# KIRKLEES METROPOLITAN COUNCIL INVESTMENT & REGENERATION SERVICE

| Reference No:         | 2024/62/93576/E                                                                             |
| Site Address:         | 32, Station Road, Shepley, Huddersfield, HD8 8DG                                            |
| Description:          | Erection of stone garden walls and timber gate (Listed Building within a Conservation Area) |

GENERAL NOTES

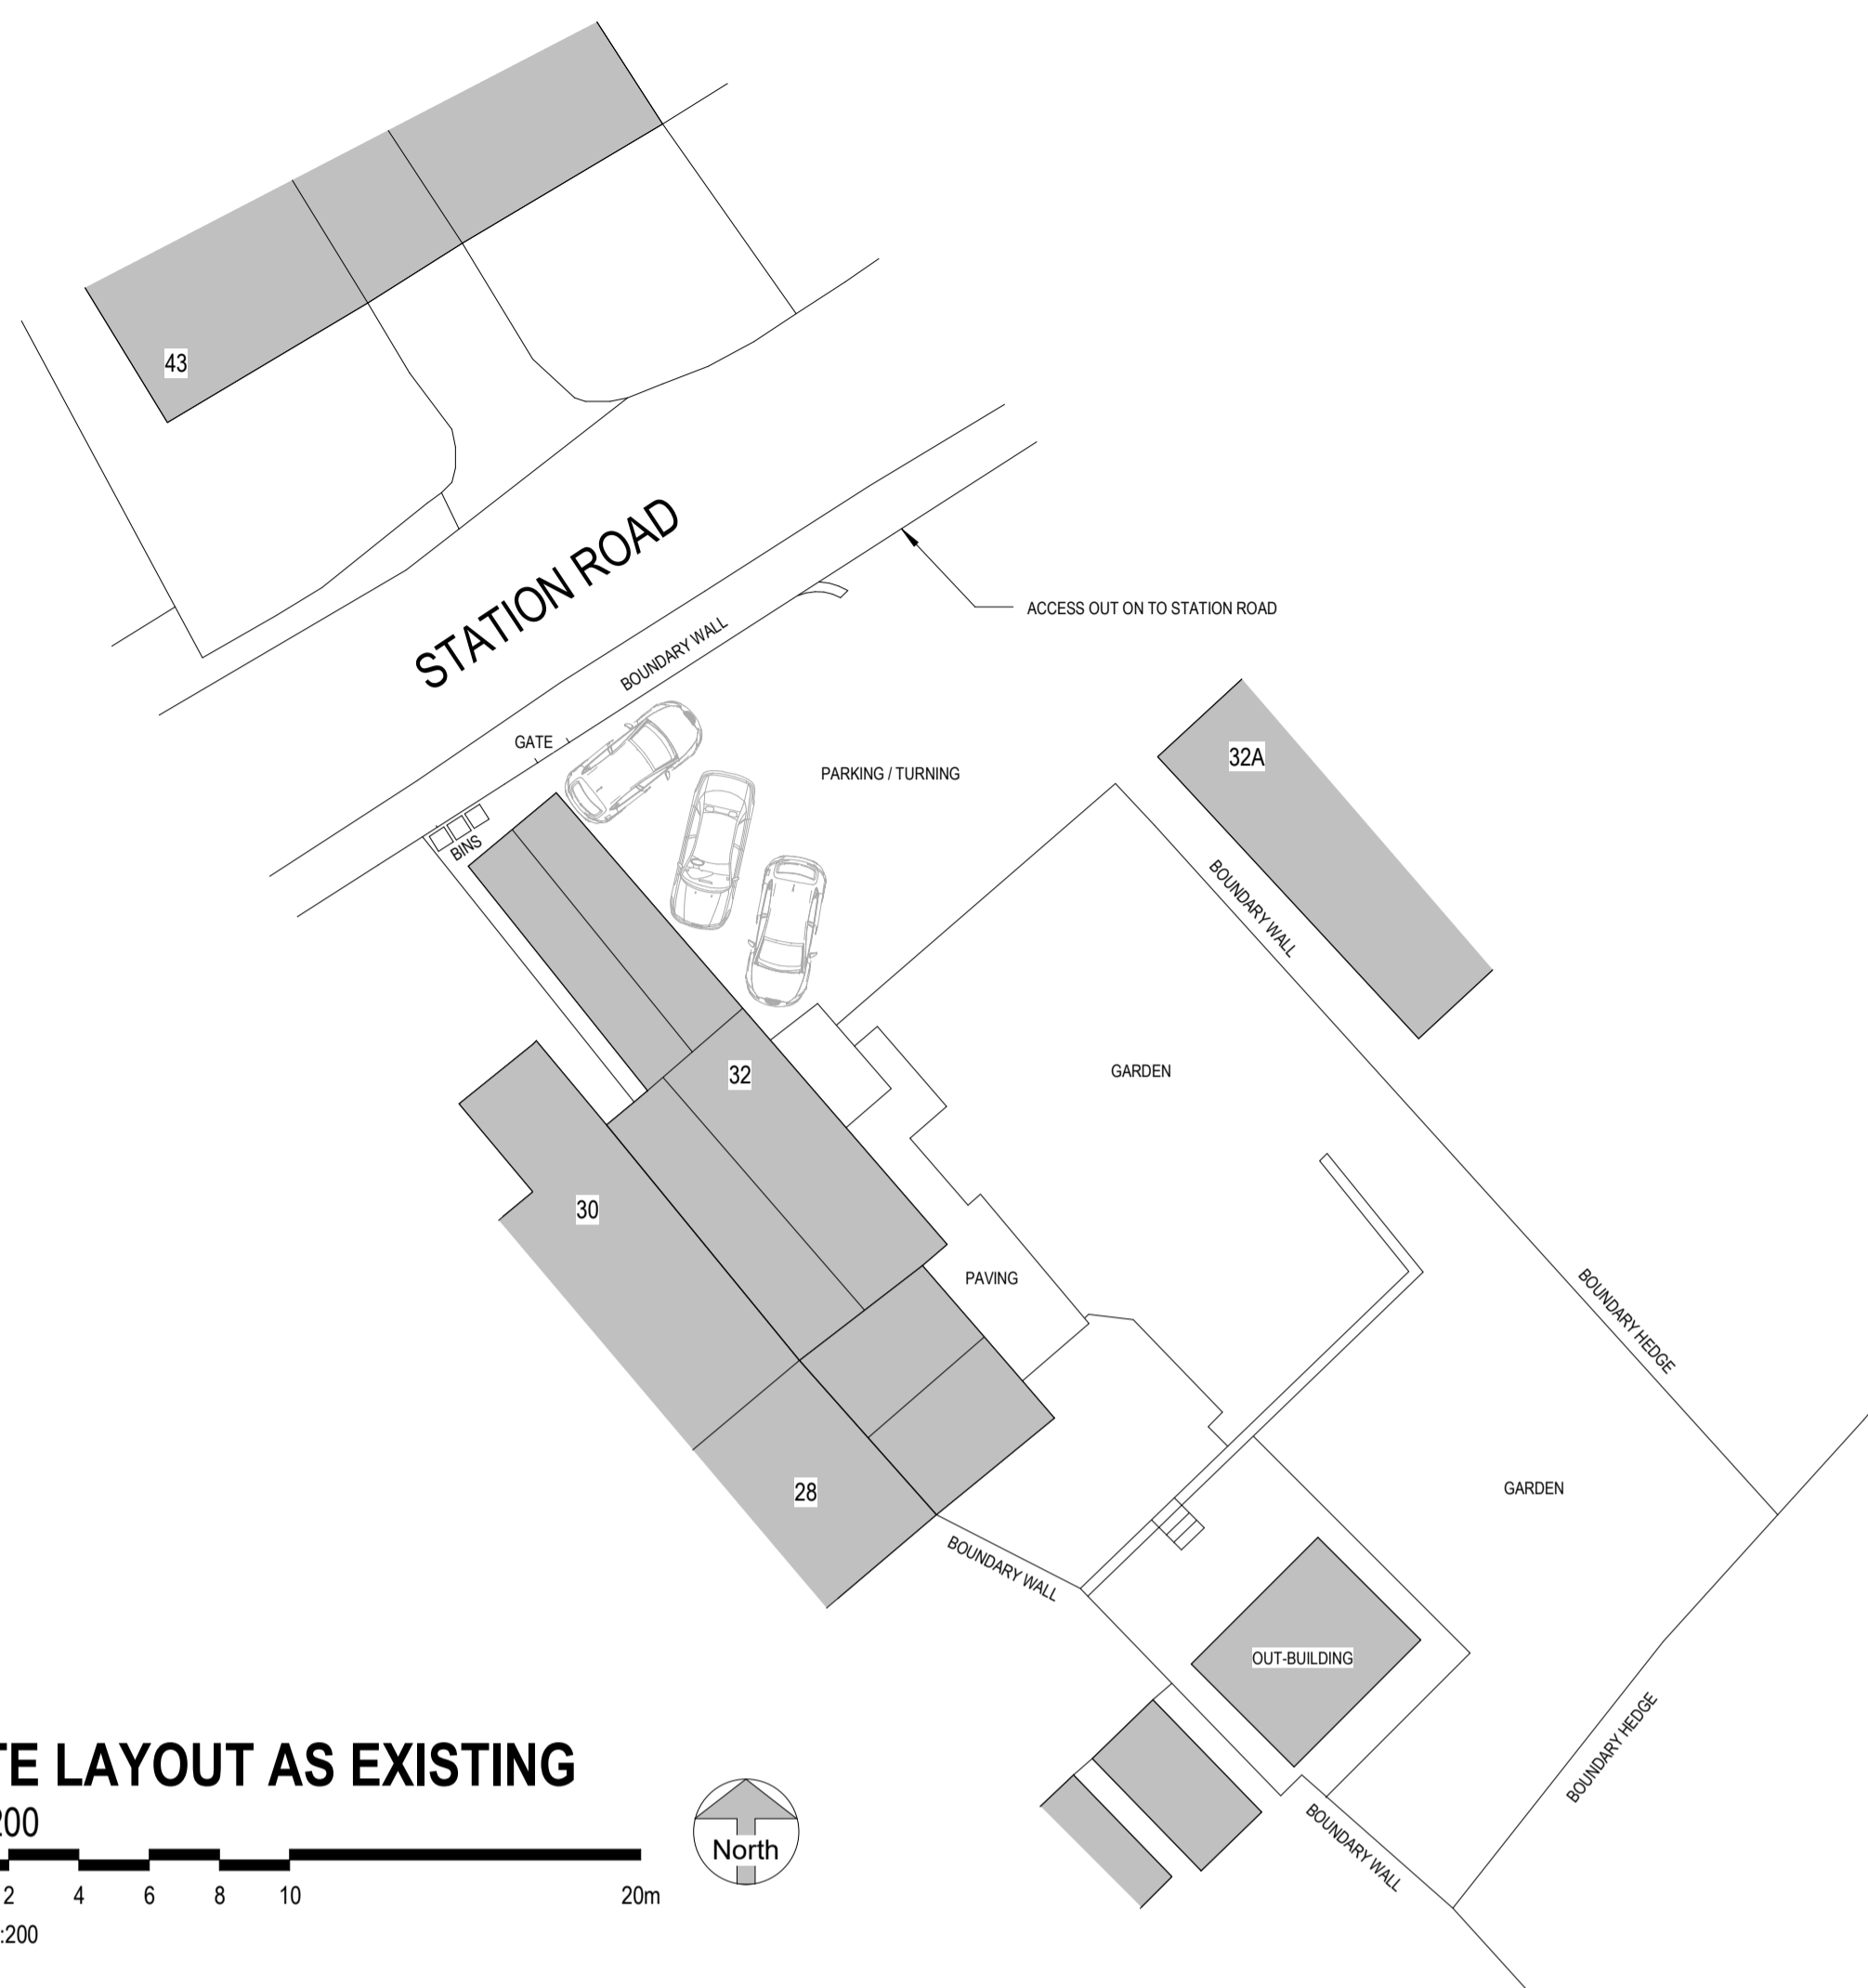
occupant. However, the wall is in a highly visible location from the street, and its construction style—including its height, stone size, and flat horizontal coping—does not complement the character of the listed building or the surrounding conservation area. Due to its design and scale, the walling and gate have a detrimental and negative effect on both the listed building and its setting. When considering harm, as set out by paragraph 212 of the NPPF, great weight should be given to the asset's conservation. Paragraph 213 goes on to state that any harm should require clear and convincing justification. The development results in less than substantial harm which will be weighed against the public benefits of the proposal. While paragraphs 4.6, 4.7, and 6.04 of the statement highlight security benefits for the applicant, these considerations do not constitute a public benefit or provide sufficient justification for the harm caused to the listed building and conservation area. As such the development proposals would result in harm to the character and setting of the listed building and conservation area contrary to Local Plan Policy LP35 and Chapter 16 of the NPPF.

The wall is prominently visible from the street, and its construction style—including its height, stone size, and flat horizontal coping—does not harmonize with the character of the listed building or the surrounding conservation area. Consequently, due to its design and scale, the works have a detrimental impact on both the listed building and its setting which are intrinsic in terms of the character of the area and visual amenity. Therefore, the walling and gate are not considered acceptable in terms of visual amenity.

The walling and gate, given the prominent position together with the construction style, height, stone size and use of flat, horizontal coping does not harmonise with the character of the listed building or the surrounding conservation area and as such has a negative impact on the heritage asset and visual amenity. To permit the proposals would be contrary to Policies LP24 & LP35 of the Kirklees Local Plan, KDP1 of the House Extensions & Alterations SPD along with Chapters 12 & 16 of the National planning Policy Framework.

1. Due to the height, method of construction, materials, including stone size and use of flat, horizontal coping, as well as the prominent position, the walling and gate do not harmonise with the character of the listed building or the surrounding conservation area detracting from the character of the host building, its setting and designated heritage assets. To permit the proposals would be contrary to Policies LP24 & LP35 of the Kirklees Local Plan, KDP1 of the House Extensions & Alterations SPD along with Chapters 12 & 16 of the National planning Policy Framework.
